Our ref: DA-384/2019
Your Ref: SSD-10352

**WAVERLEY COUNCIL SUBMISSION TO APPLICANT'S SUPPLEMENTARY RESPONSE TO SUBMISSIONS
State Significant Development Application (SSD-10352) for Moriah College Redevelopment
Queens Park Road, Queens Park
(Waverley Council Ref.: DA-384/2019)**

Figure 70 – Stage 1A Landscape Masterplan

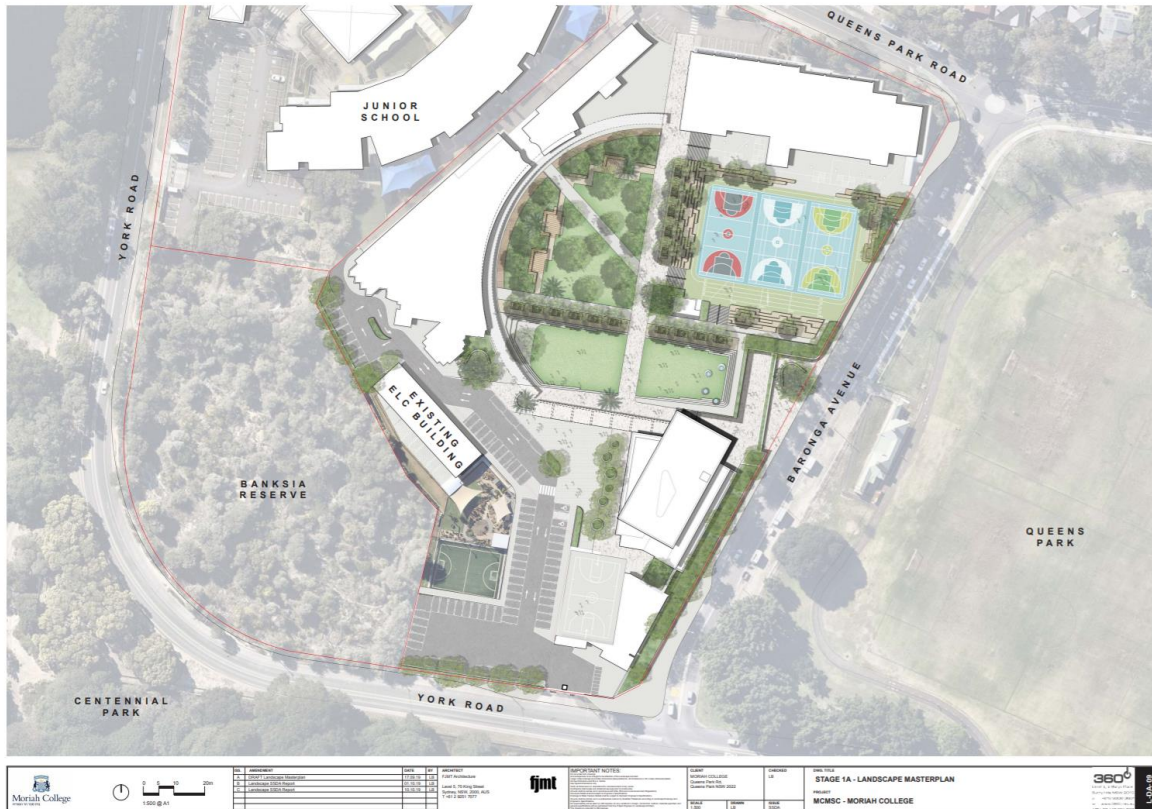
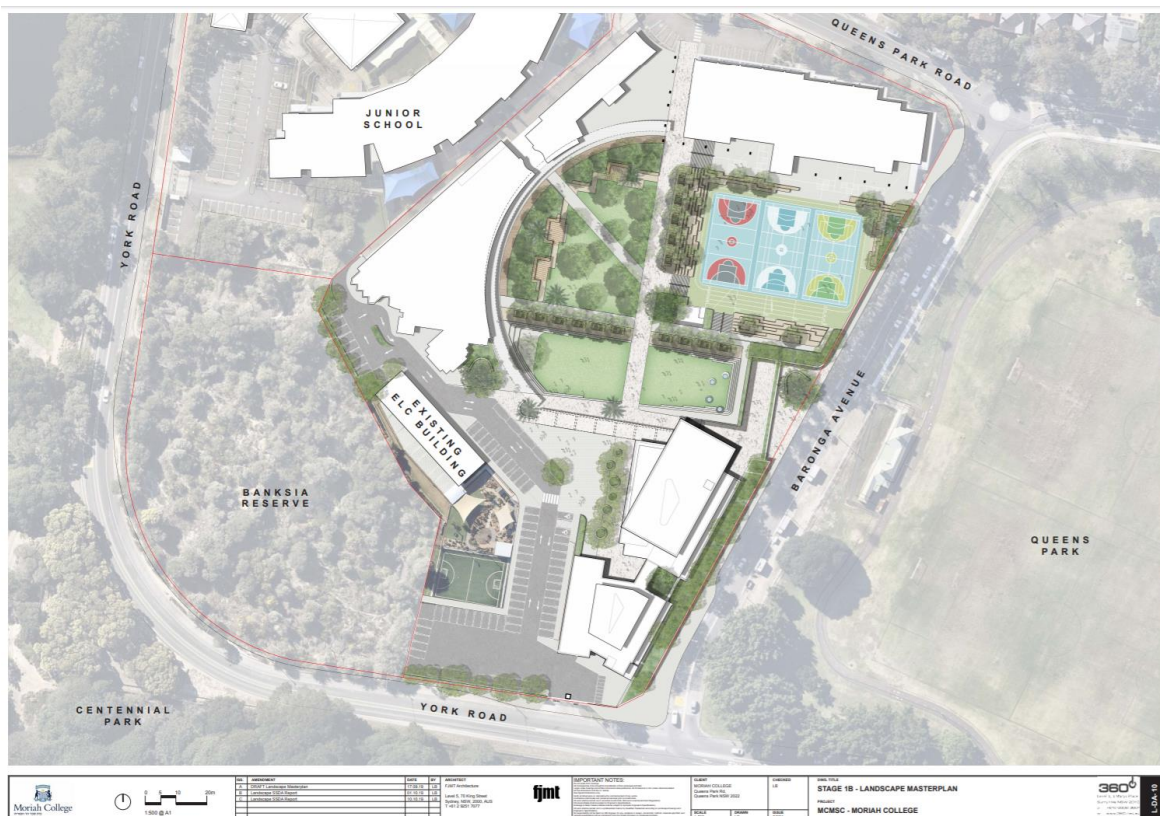
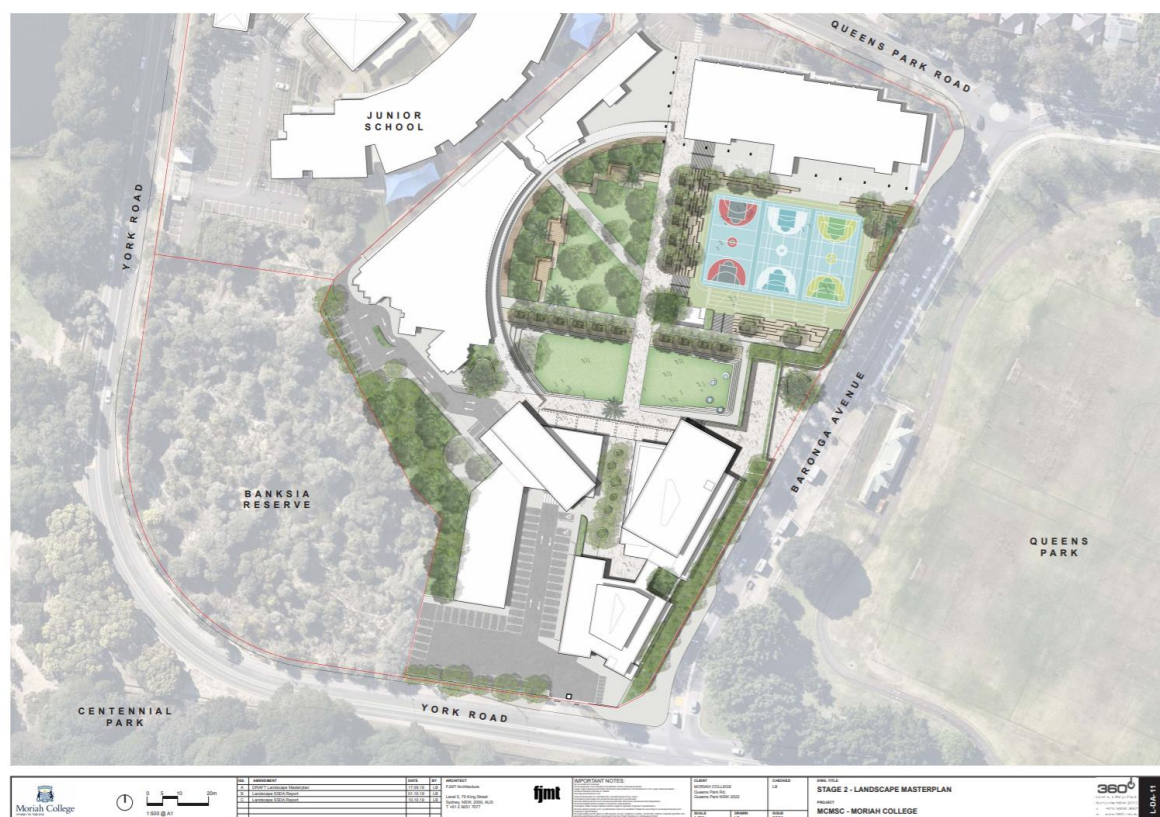
The landscape plans still do not satisfy the DCP Control for development proposal adjoining remnant vegetation.

Planting schedules have now been included on the amended plans, making it clear that these plans do not meet the control.

Some of the plant species identified on the Landscape Plans as ESBS are not ESBS species according to the *ESBS Recovery Plan 2004* e.g. some eucalypts. Regardless, the Control requires the 90% of species to be selected from Annexure B2-1.

It also appears that numbers of native shrubs have been inflated to attempt to meet the control, but would not fit into the spaces proposed .e.g almost 6000 plants (including around 2000 shrubs that will grow to widths of around 2 m or more) into a space of 2018 m² (Early Learning Centre).
